From: Fiona Fitzgerald
Sent: 04 September 2014 11:48
To: Simon Davis
Subject: RE: Barnham Road Express EG/58/14

From: Simon Davis
Sent: 02 September 2014 12:26
To: Fiona Fitzgerald
Cc: James Smith
Subject: FW: Barnham Road Express EG/58/14

REAR ELEVATION-C AS PROPOSED
SCALE 1:50

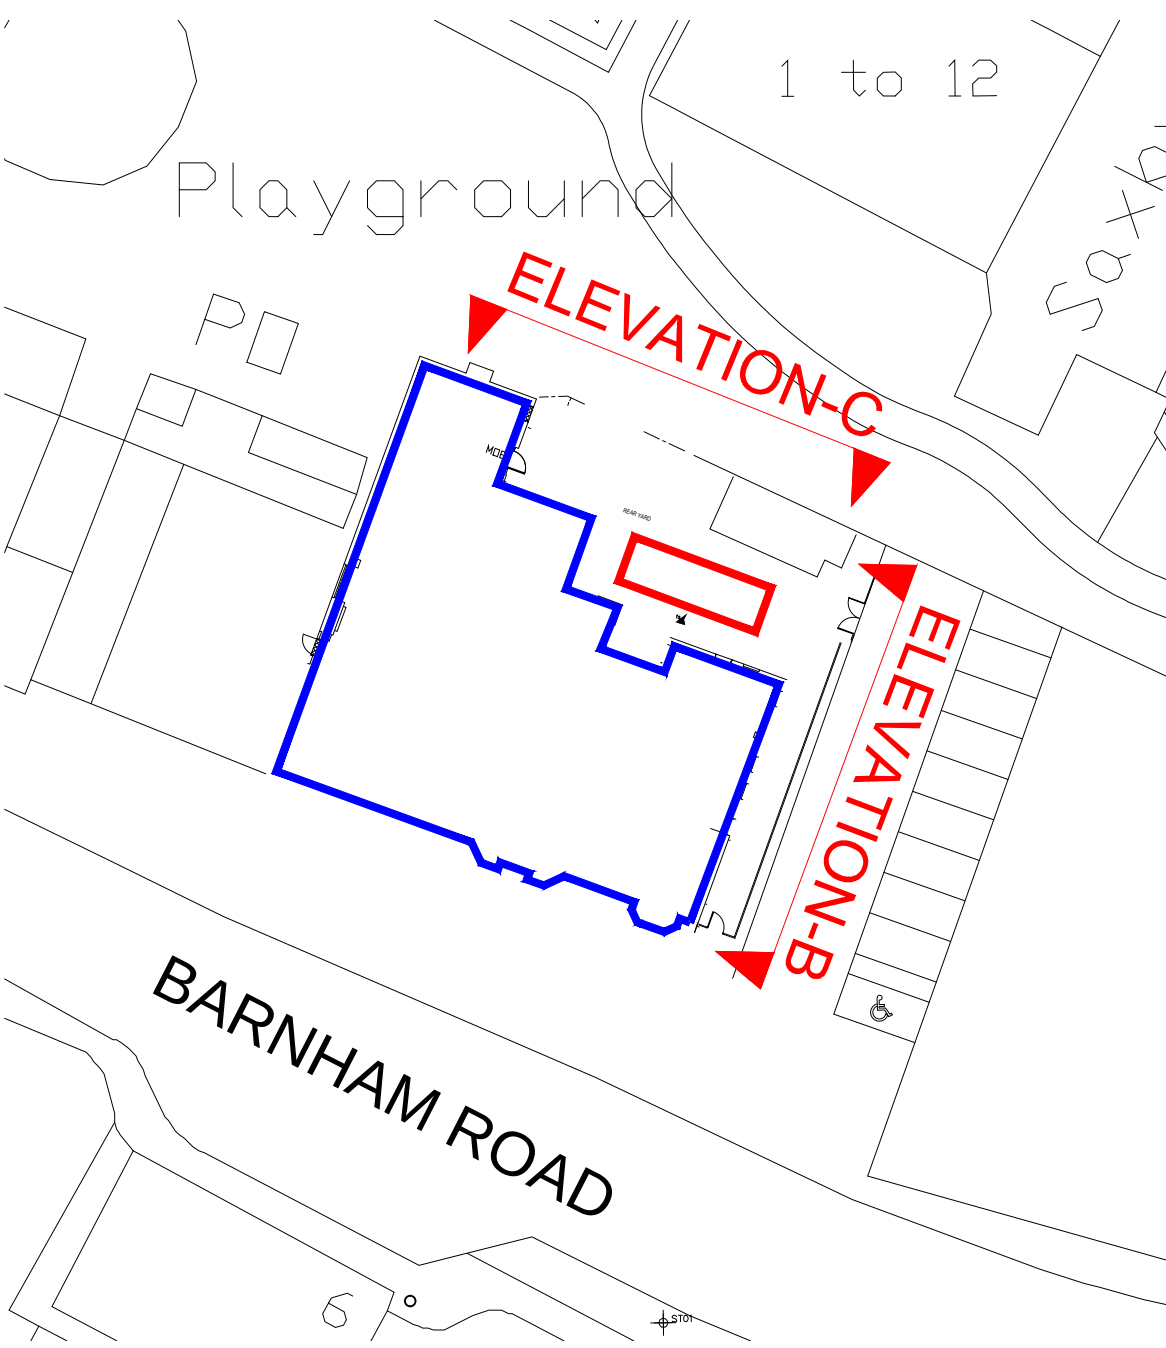
1. The acoustic report does not state specifically which property he is assuming is the closest residential property. This is alluded to in 8.2 ‘assessment position’ but not stated. Please ask the acoustic consultant to state the address of the property for avoidance of doubt. Please also ask the acoustic consultant to confirm that they are certain that this is indeed the nearest residential property. Has he taken account of any flats above the commercial premises in this row of shops which may be affected by any potential noise?

4. Each of the noise sources appears to have been assessed in isolation. The worst case scenario would surely be that they would all be working at the same time. Please ask the acoustic consultant to address this within his calculations.

5. Please ask the applicant to confirm whether there will be a compactor on site. If so, where will it be located?”

The flats are indeed slightly closer, but due to the plant being located against the extension wall to the rear, the greater noise impact will be at the Assessment Position originally selected by the consultant in the report.

This is incorrect. For the day-time assessment the Assessment Position Sound Pressure Levels (31 dB, 37 dB, 37 dB & 24 dB) are combined to produce the specific noise level for all 4 units (41 dB). At night, only the condenser operates (at a capped speed) producing a maximum of 24 dB.

This is outside the scope of the report.
